NORTH FALLS

Offshore Wind Farm

Applicant's Response to Deadline 5 submissions

Document Reference:	9.87
Volume:	9
Date:	June 2025
Revision:	0

# **Onshore Substation Zone of Theoretical Visibility and Viewpoint Locations with Dedham Vale National Landscape**

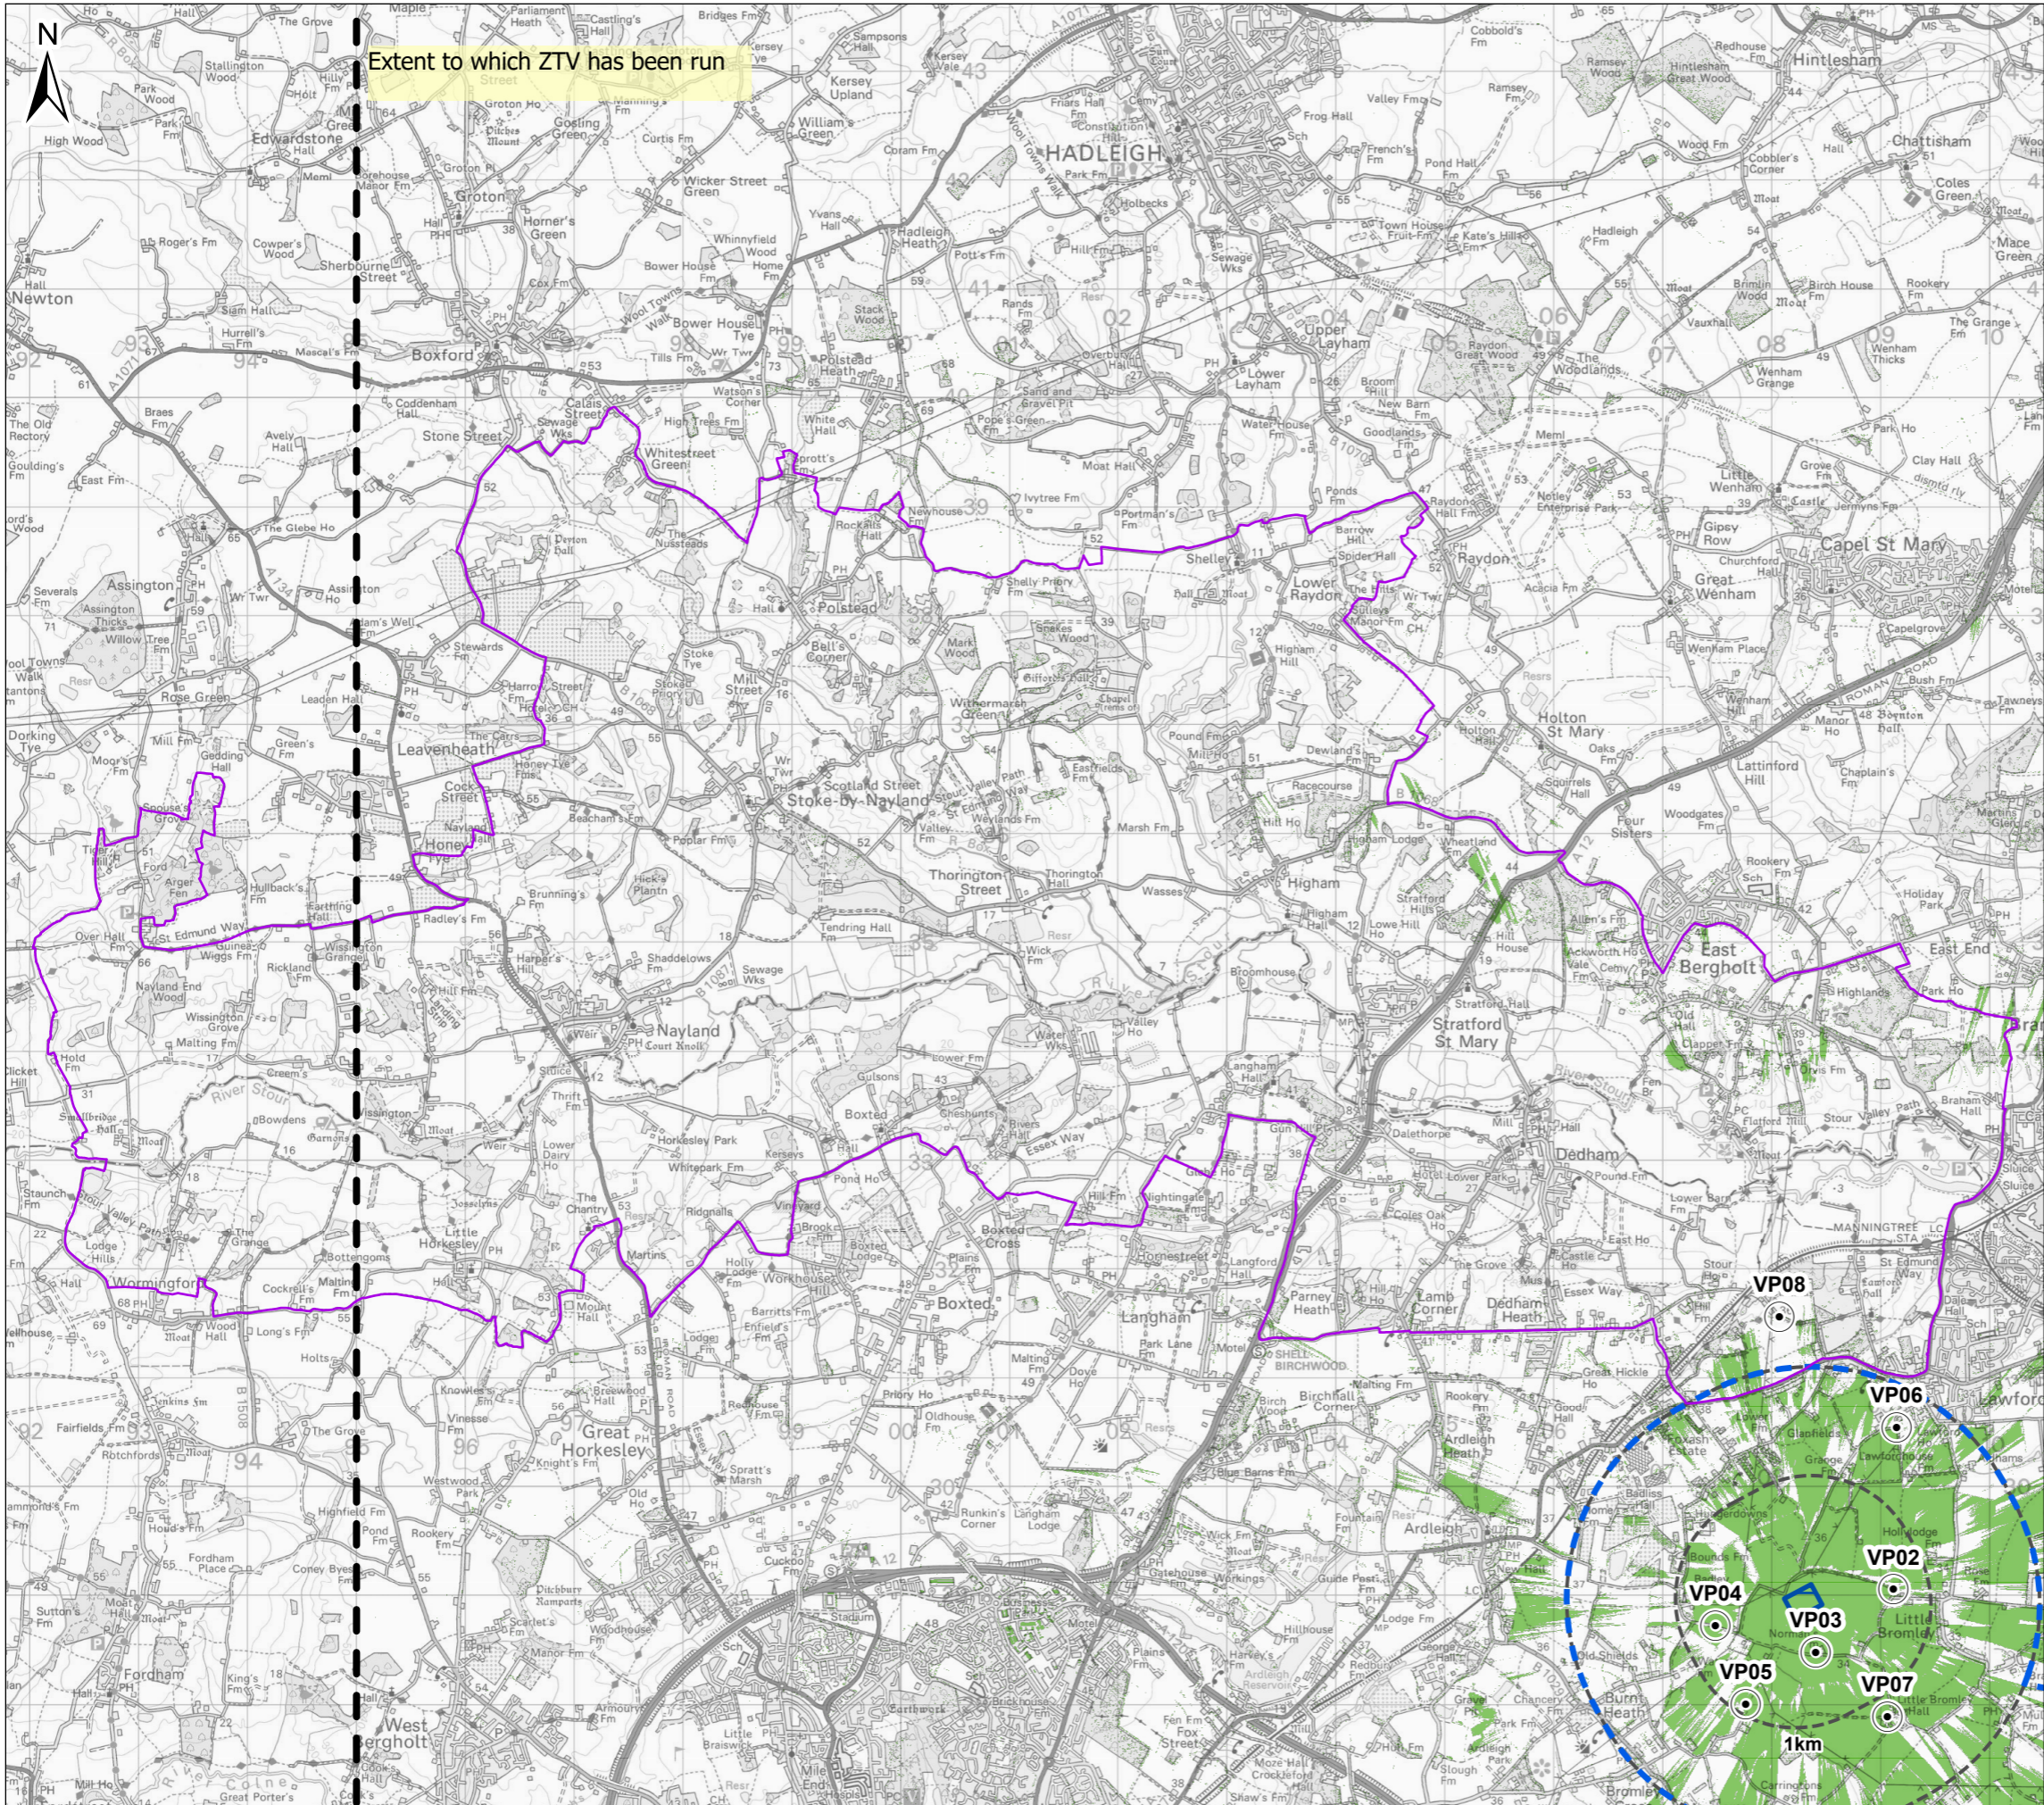
REF	THEME	ECC TDC COMMENT	APPLICANT'S RESPONSE
		closer. It is not clear whether other viewpoints within the National Landscape or its setting were explored or whether the enhanced duty under LURA 2023 has been addressed. A figure should be provided combining the viewpoints with the ZTV and National Landscape boundaries, to make understanding of their relationship easier. We propose additional viewpoints are required to demonstrate that there are no significant impacts on the National Landscapes and their settings. Closer viewpoints and visualisations have been made available by the Five Estuaries applicant.	
REP5-089_b12	Landscape: Onshore Substation	Much of the success of the planting will depend on the nature of the aftercare in the LEMP, how replacement planting is monitored, especially in the final year of a maintenance period and whether the mitigation planting is maintained for the life of the installation. We understand that the LEMP is an iterative document and would wish to comment further on this document.	Requirement 7 of the Draft DCO [REP5-008] secures the development and implementation of a detailed written landscape scheme, including monitoring, to be substantially in accordance with the OLEMS [REP5-024] , and subject to the approval of the Local Planning Authority.

1 New visualisation (VP9) from Barn Lane - Grange Road

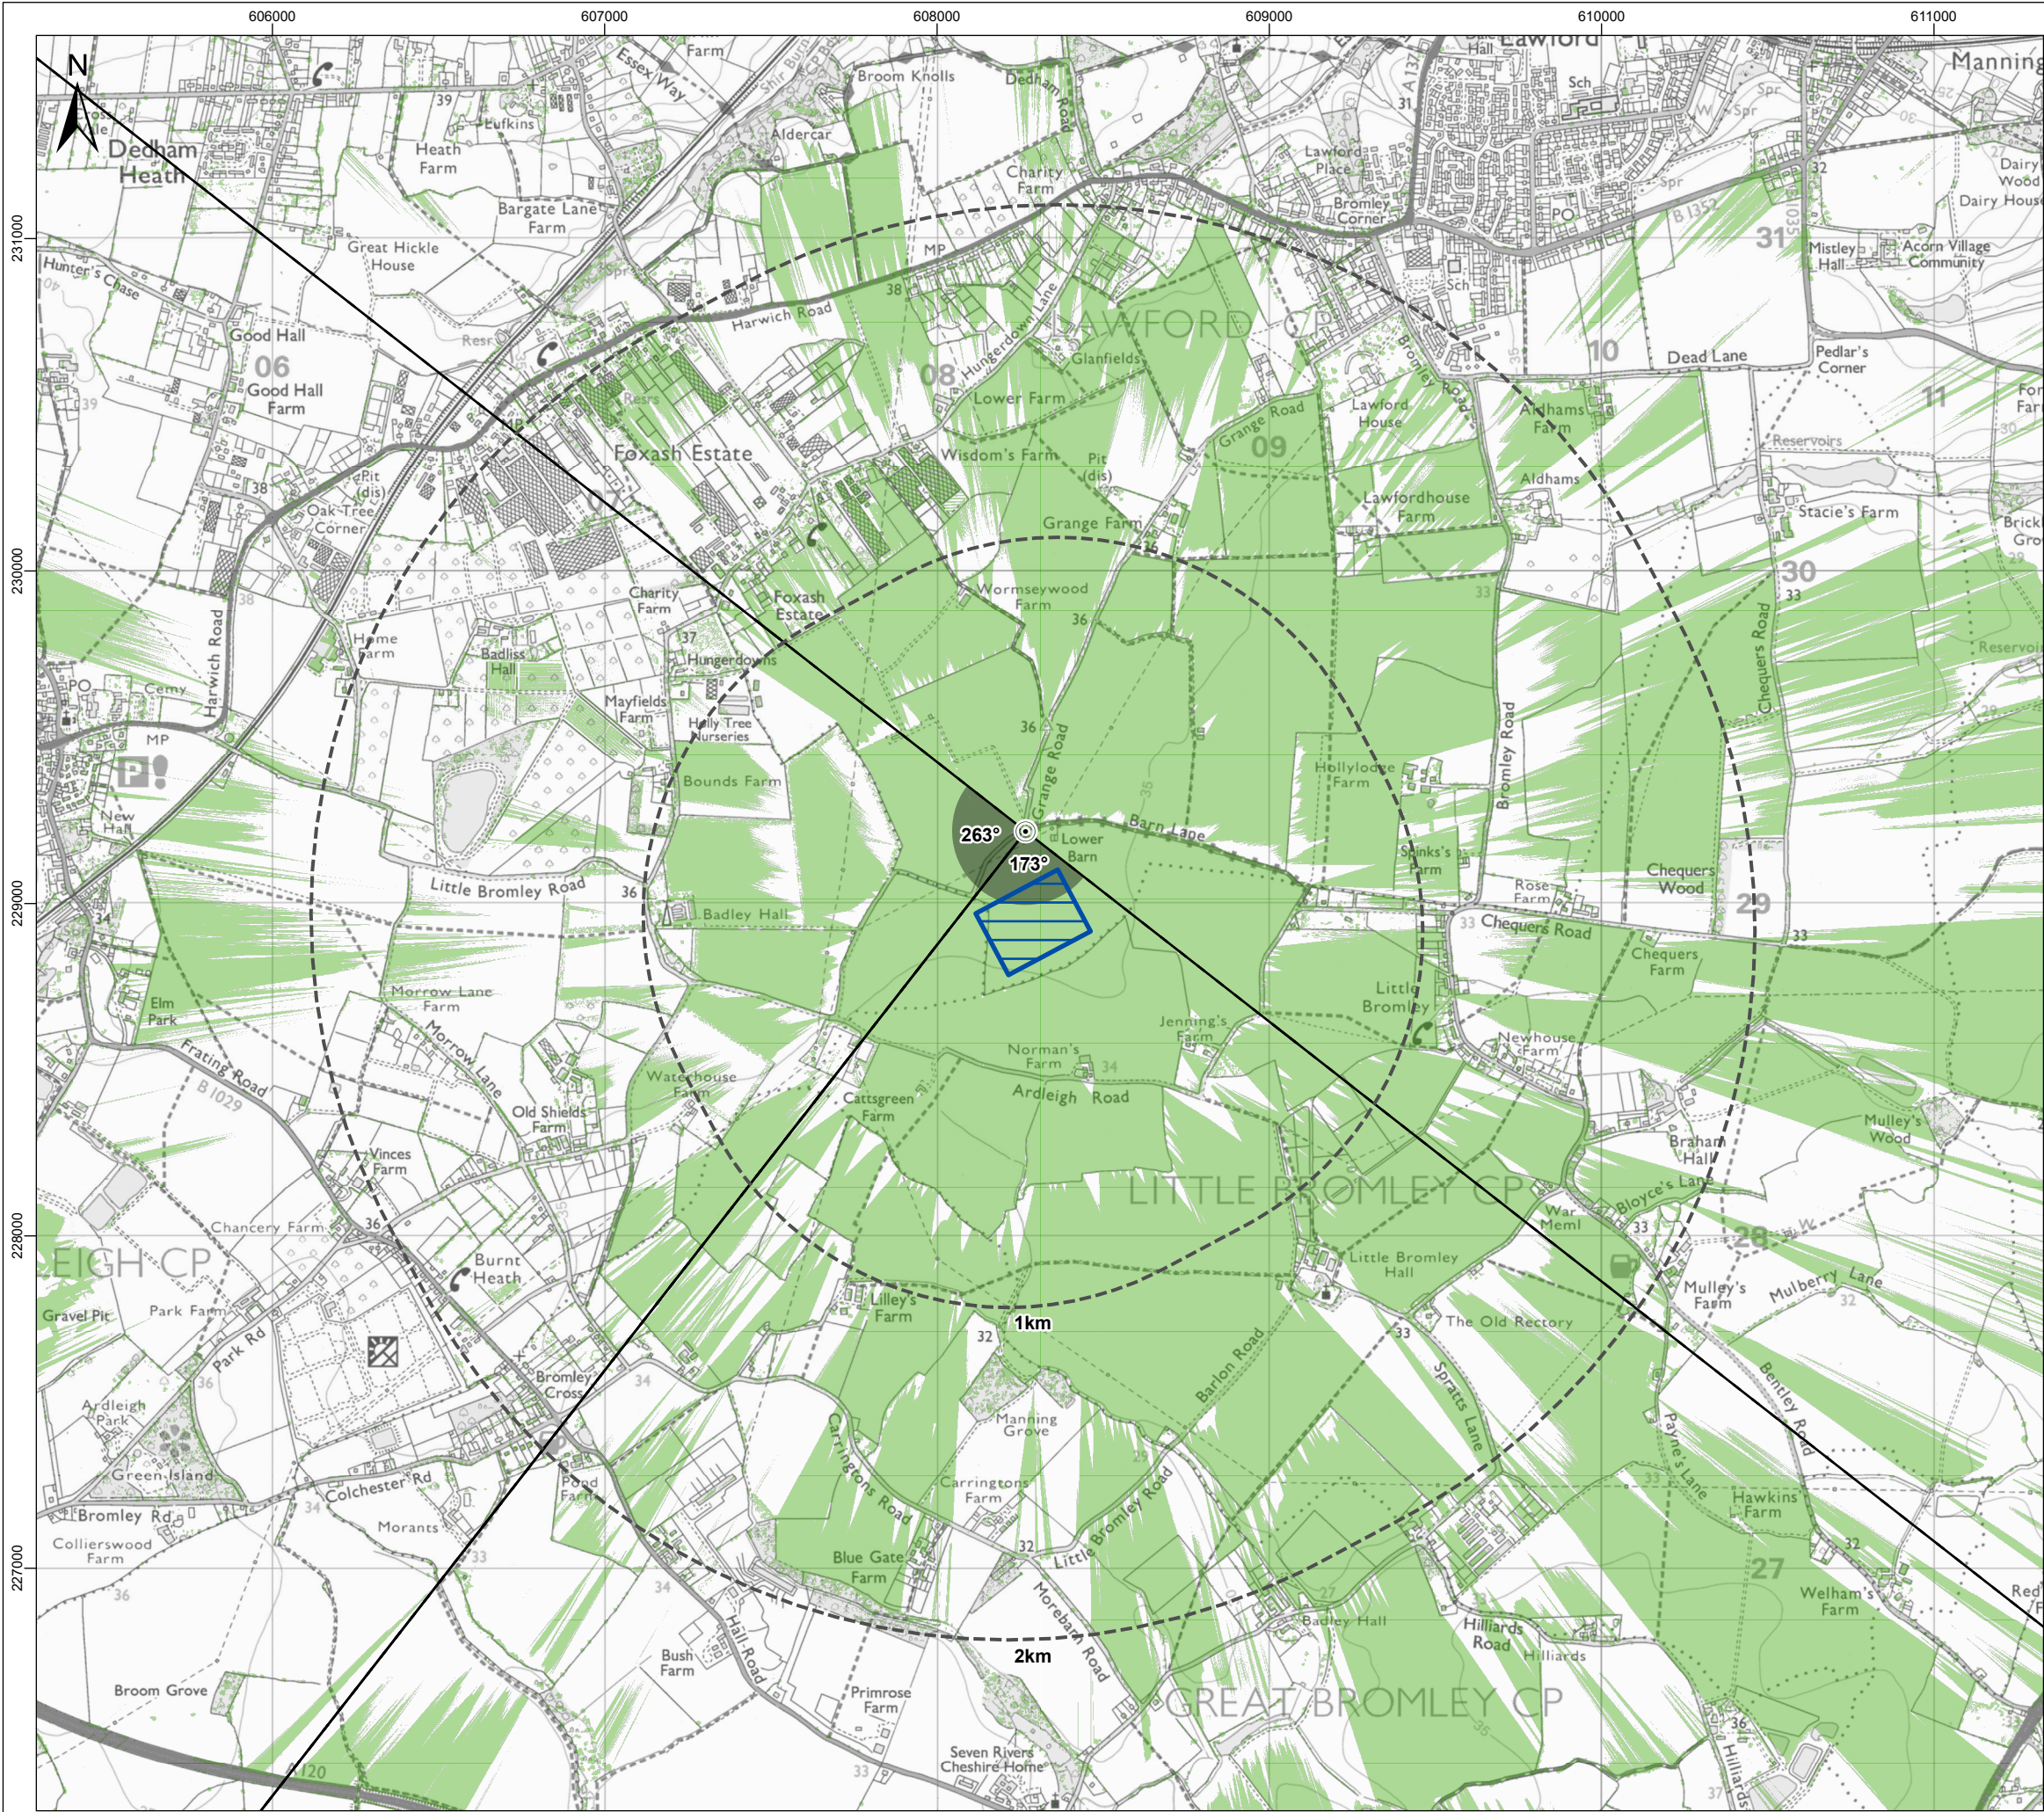
REP5-089_b9	Landscape: Onshore Substation	It is unclear why no viewpoints have been taken from Grange Road to the west/north-west of the site when there are open views along much of the eastern boundary and the proposed facility lies closest to it. There appear to be no viewpoints to the north-west of the site within the study area at all, despite there being several PRoW as well in this direction. At least two viewpoints are needed along Grange Road close to the site. This is also the boundary around which the least mitigation is possible increasing the likelihood of significant impacts from this direction. Despite its name, Grange Road is a narrow lane at this point, characteristic of this landscape and so receptors using it should be assessed appropriately. VP6 is over 1.5km away so likely impacts judged from that distance are likely limited.	See response to REP5-089_b8 above.
REP5-089_b10	Landscape: Onshore Substation	We also suggest that at least one further viewpoint is needed from the PRoW network to the north of the development to demonstrate what impacts are likely between 1-1.5 km in this direction.	See response to REP5-089_b8 above.
